Rep for R/50/20/HH

Subject: Reference CW/CH/PLAN/20

In reference to planning application CW/CH/PLAN/20 we would like to raise two points.

DRWG TITLE: **Proposed plans**

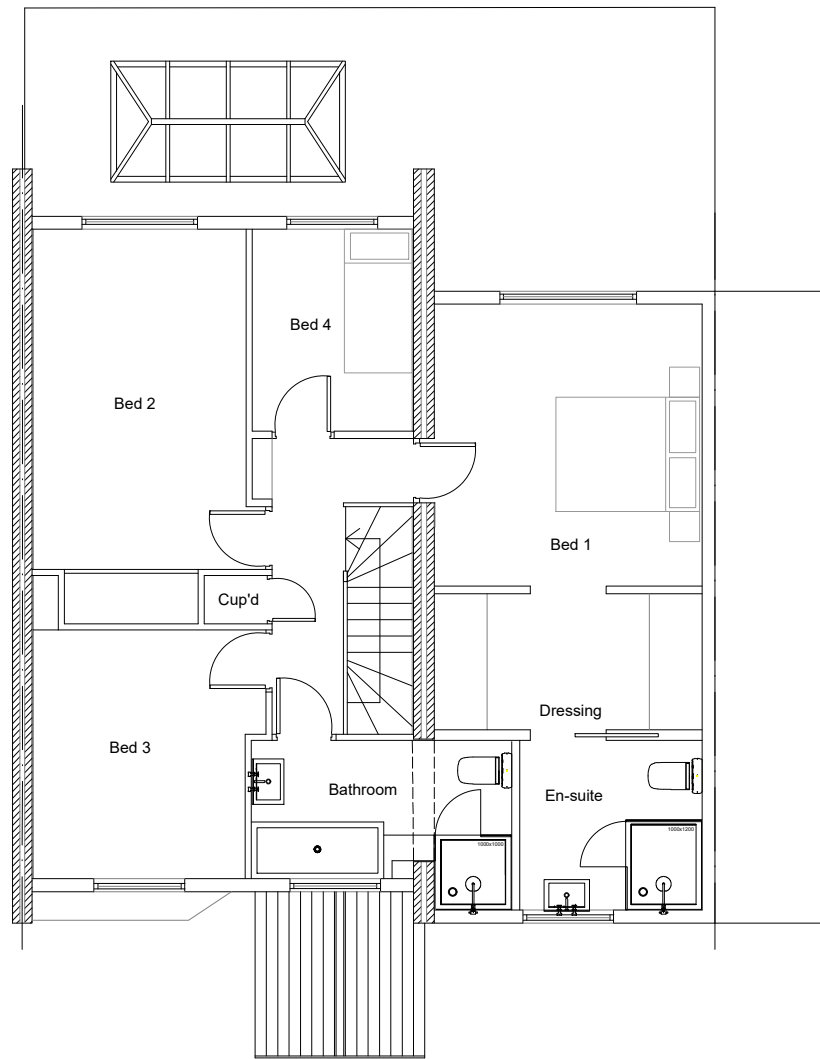
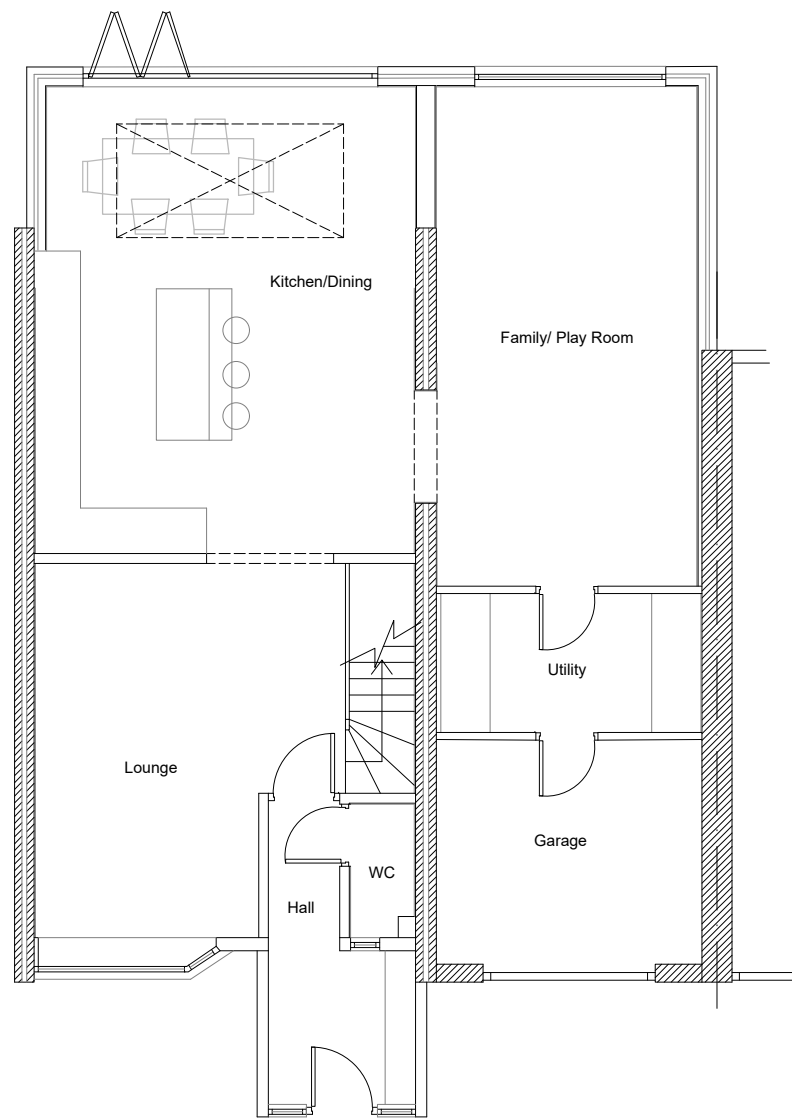
Second. The planning application states over the garage.

Originally two garages were built adjoining each other between 47/49 the full length of the house.

However number 47 changed the back half of their garage into a living room. On this premise do we conclude that as planning permission is for over the garage the extension will only extend to half the length of the house?

DRWG TITLE: **Proposed Elevations**

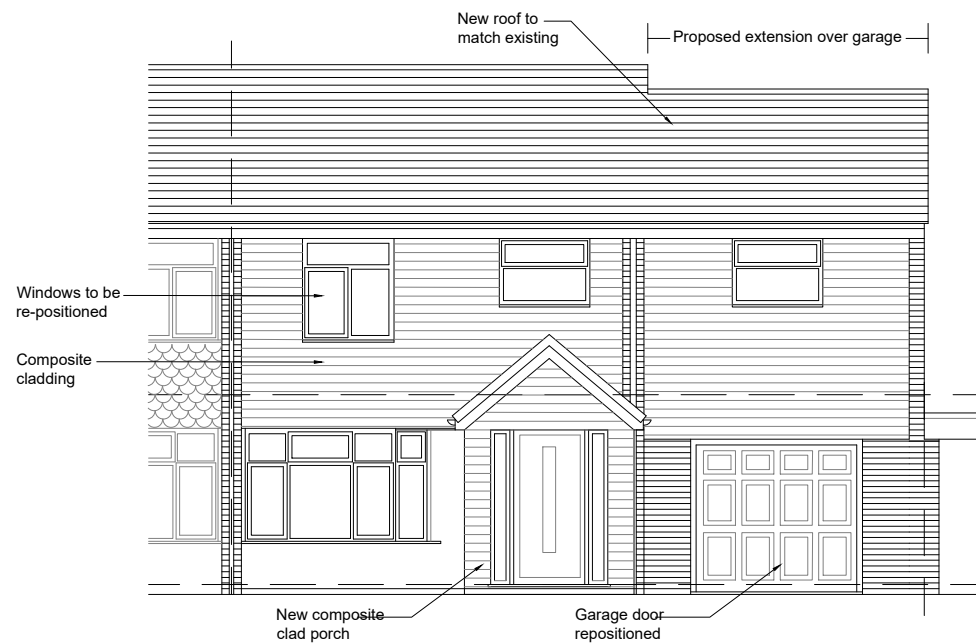
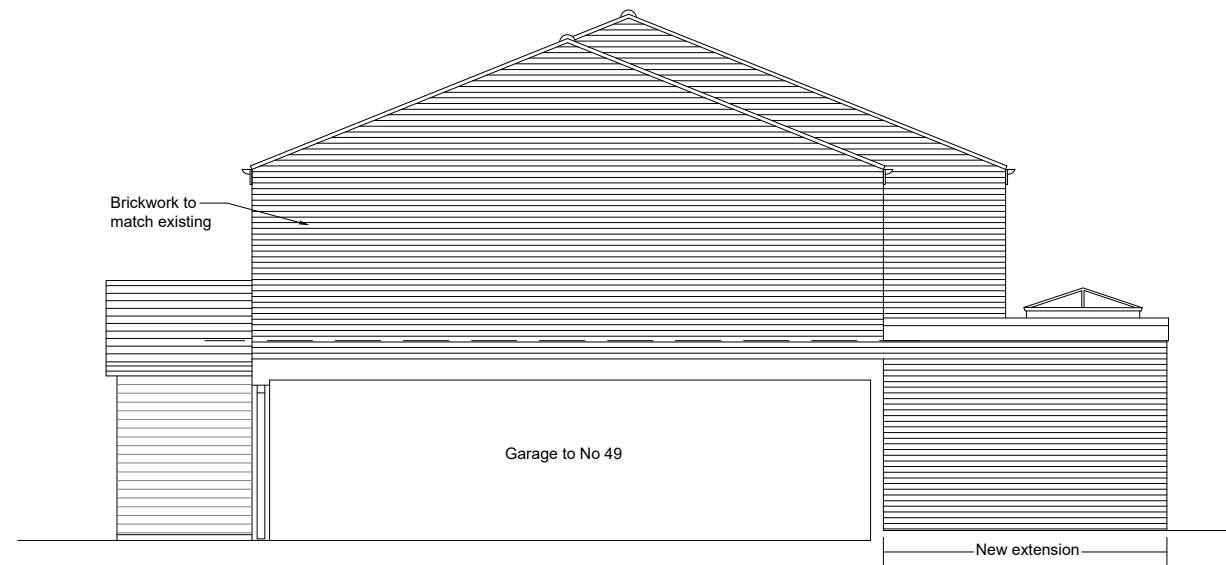
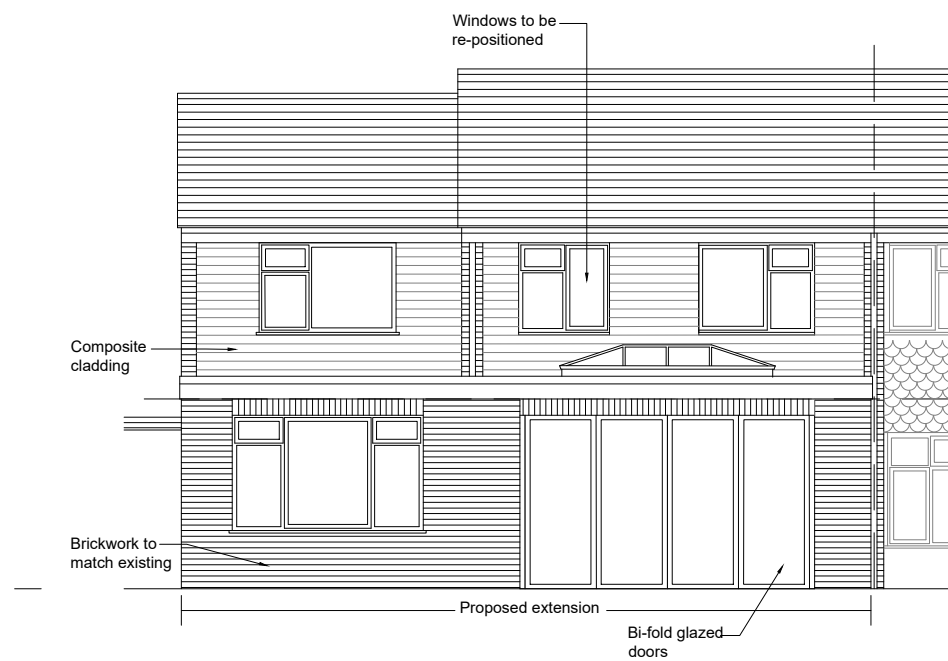
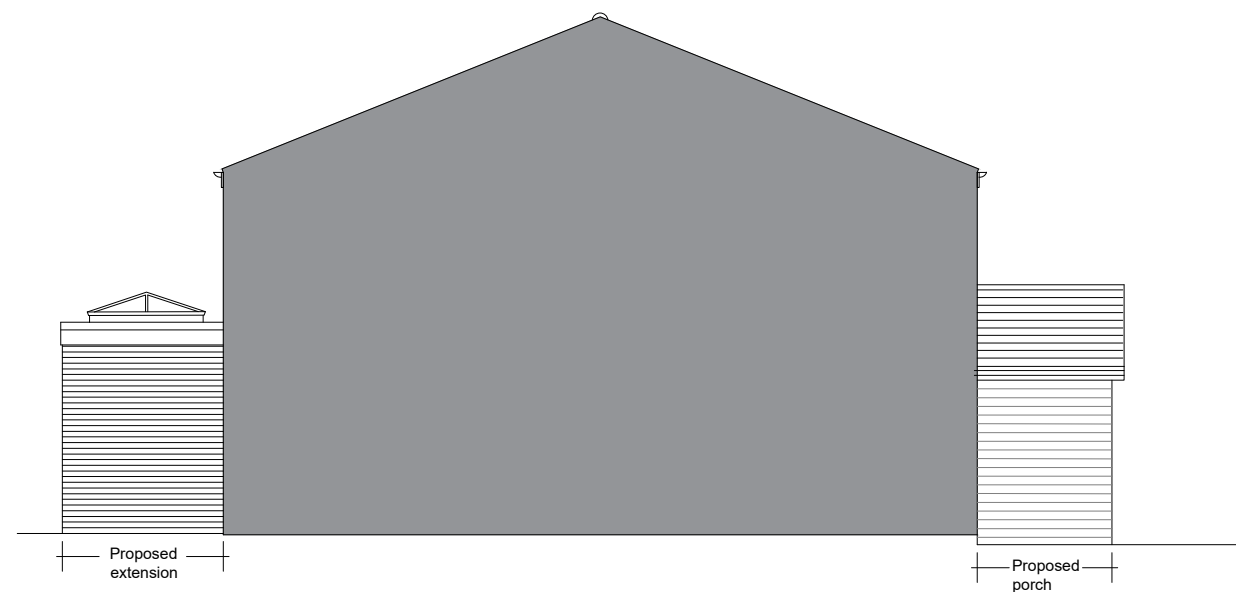
First the extension over the garage. Will the windows be situated at each end? In the future we will be applying for planning permission to build over our garage and if the windows were on the side our extension would block them.
